An
Bord
Pleanála

Board Direction
BD-005239-20
ABP-305844-19

The submissions on this file and the Inspector's report were considered at a Board meeting held on 25/02/2020.

The Board decided to grant permission generally in accordance with the Inspector's recommendation, for the following reasons and considerations, and subject to the following conditions.

Project: Woodbrook-Phase 1, Old Dublin Road, Bray, Co. Dublin
AeVal Limited Company
Dwg: Boundary Details - Entrance Design, Old Dublin Road (NTA OPTION)
Scales: As shown
Status: SHD PLANNING APPLICATION
Date: October 2019
Dwg: CS
Chd: AP
Passed

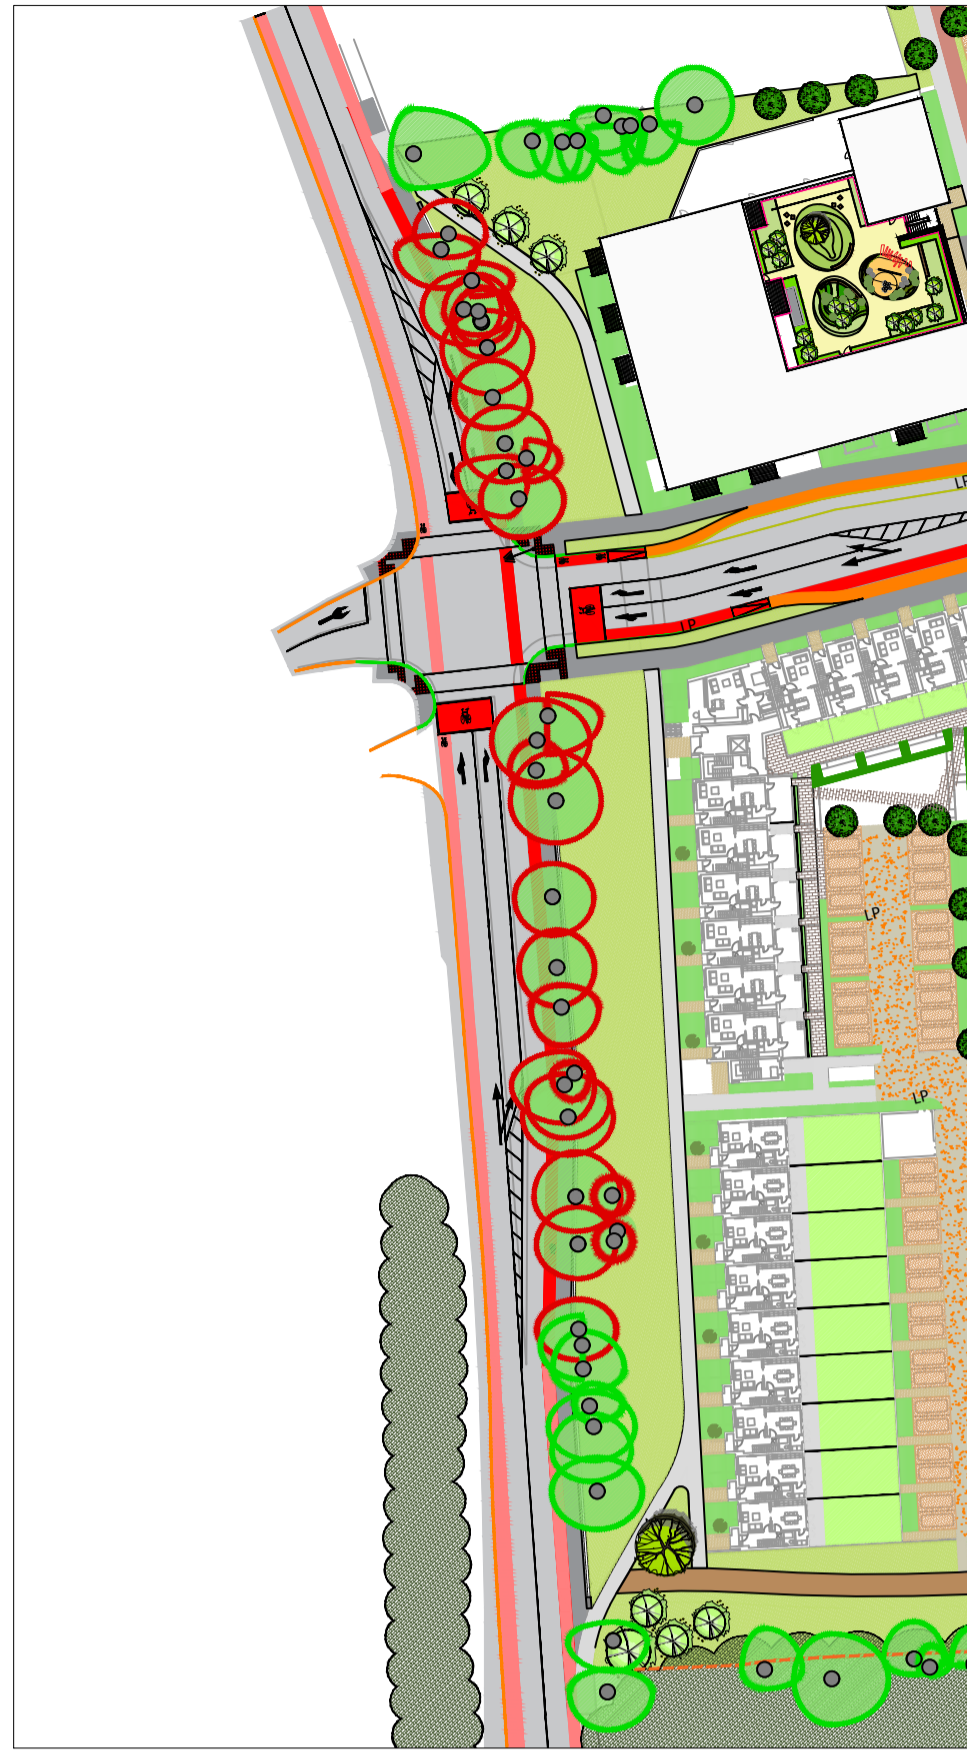
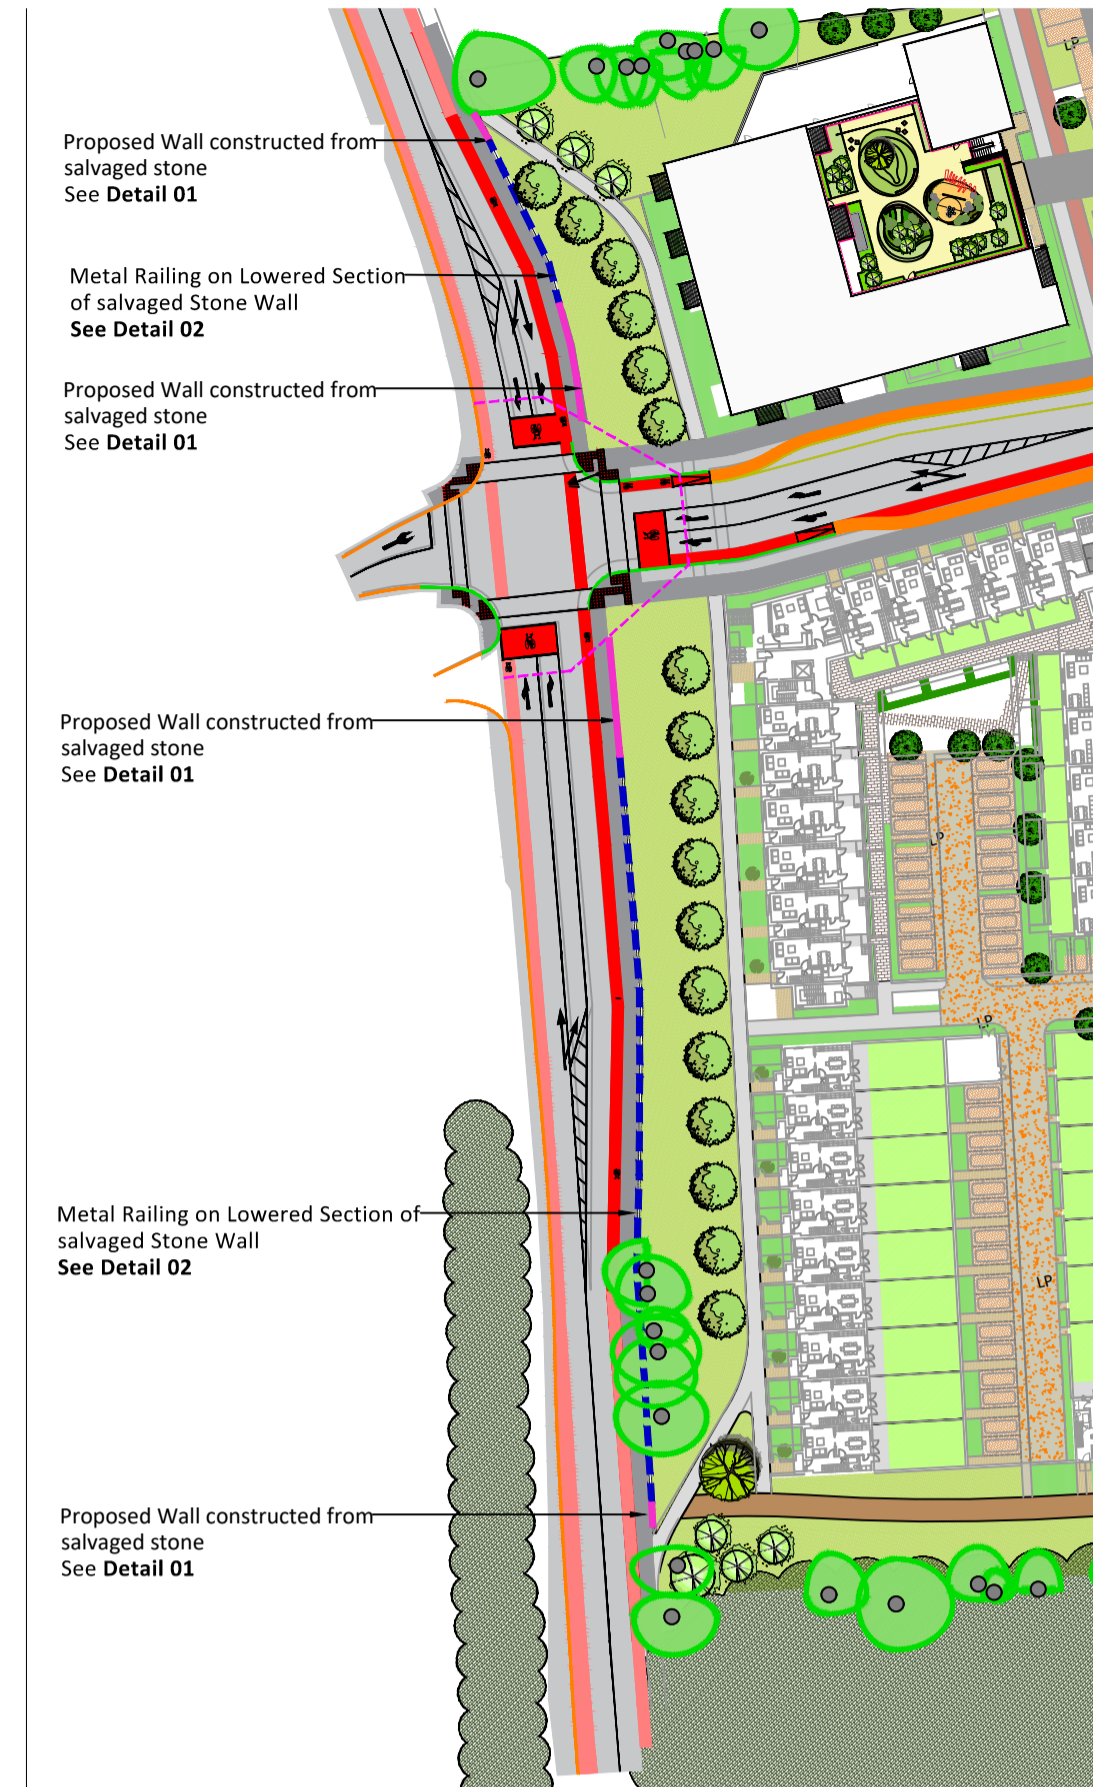
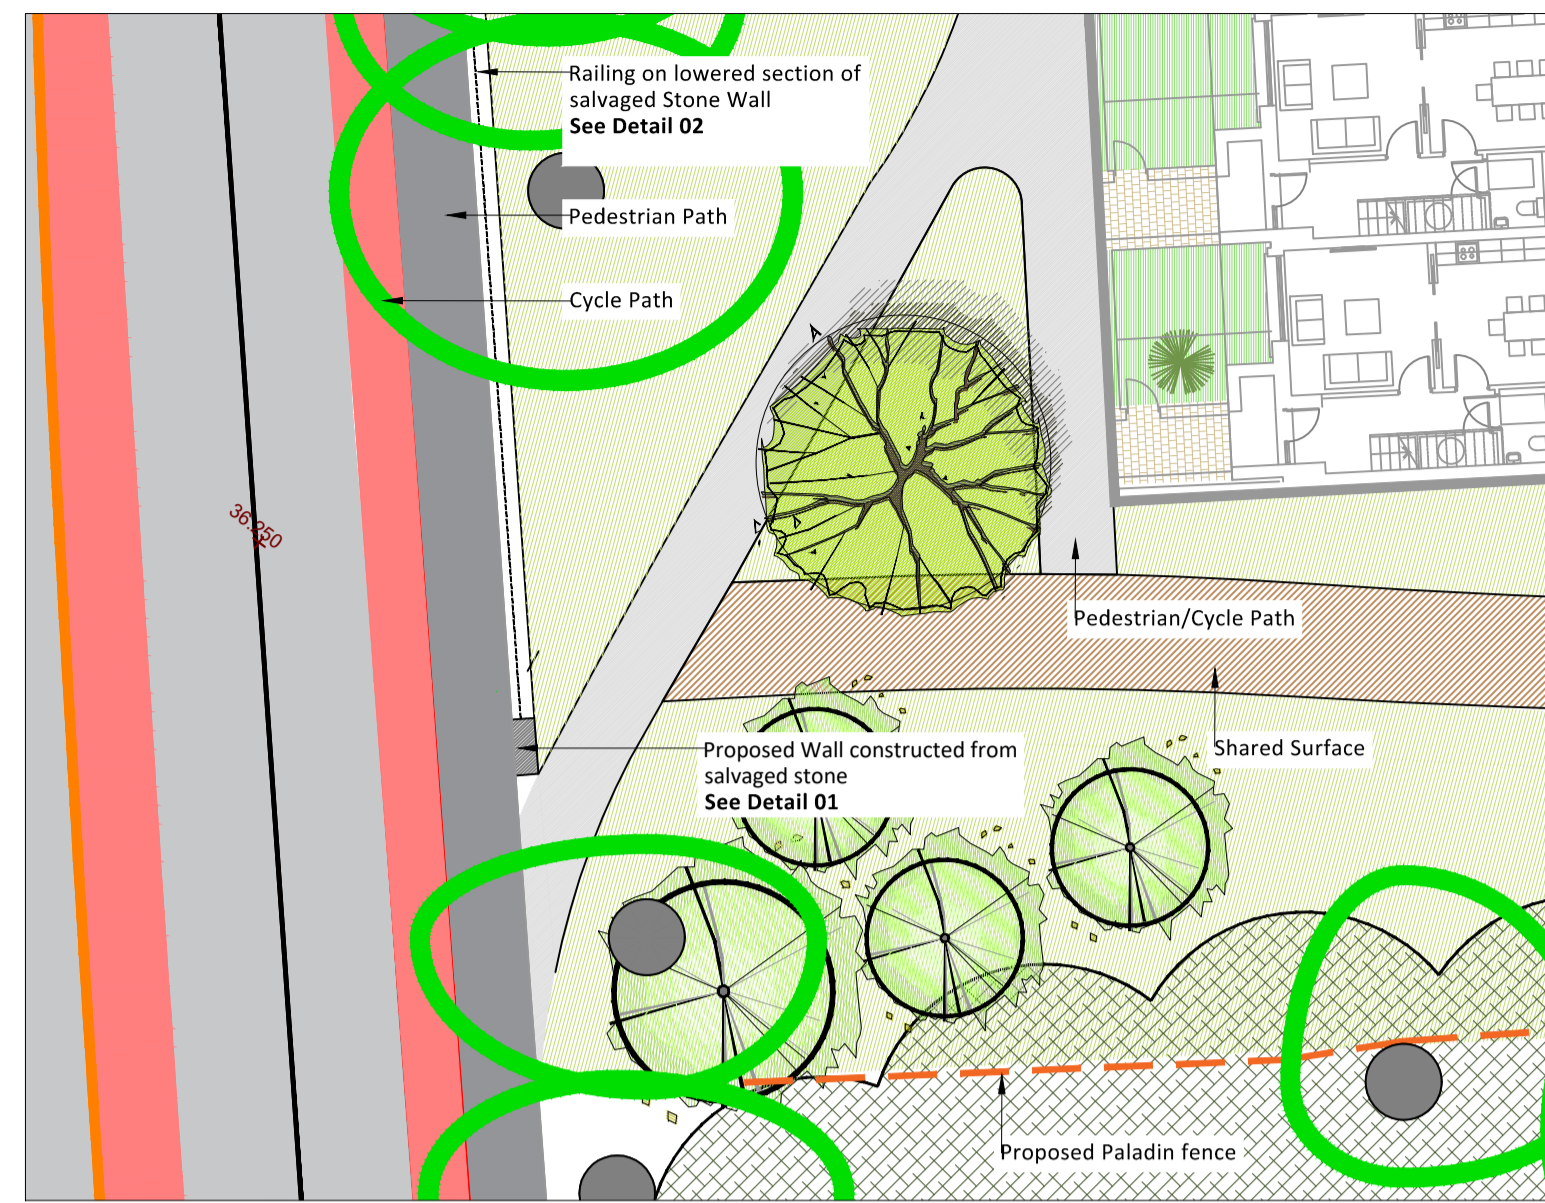
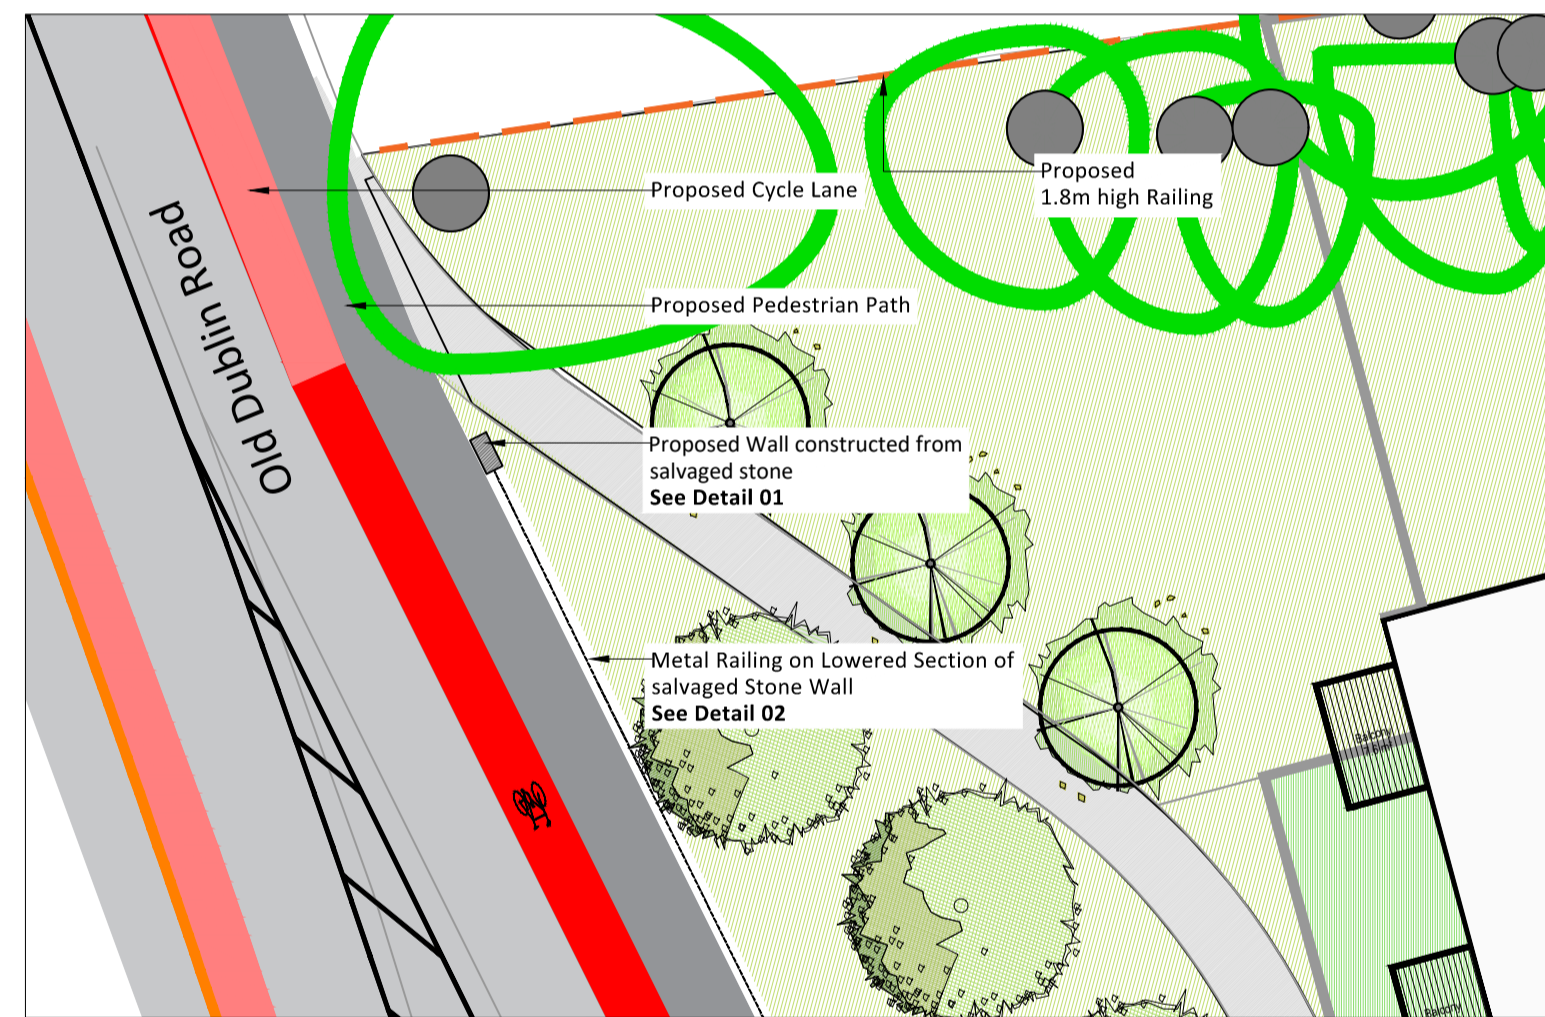
8. The proposed new road junction layout on the Old Dublin Road to serve the proposed development shall comprise of Option 1, as submitted with this application. Any future changes to the access road junction and boundary arrangements shall be the subject of a further planning application to the Local Authority.

Note: In deciding not to accept the Inspectors recommendation to proceed with the Road Junction Option 2, the Board was satisfied that Option 1 represented the optimal solution in terms of tree protection and cyclist and pedestrian safety and would be in accordance with the proper planning and sustainable development of the area.
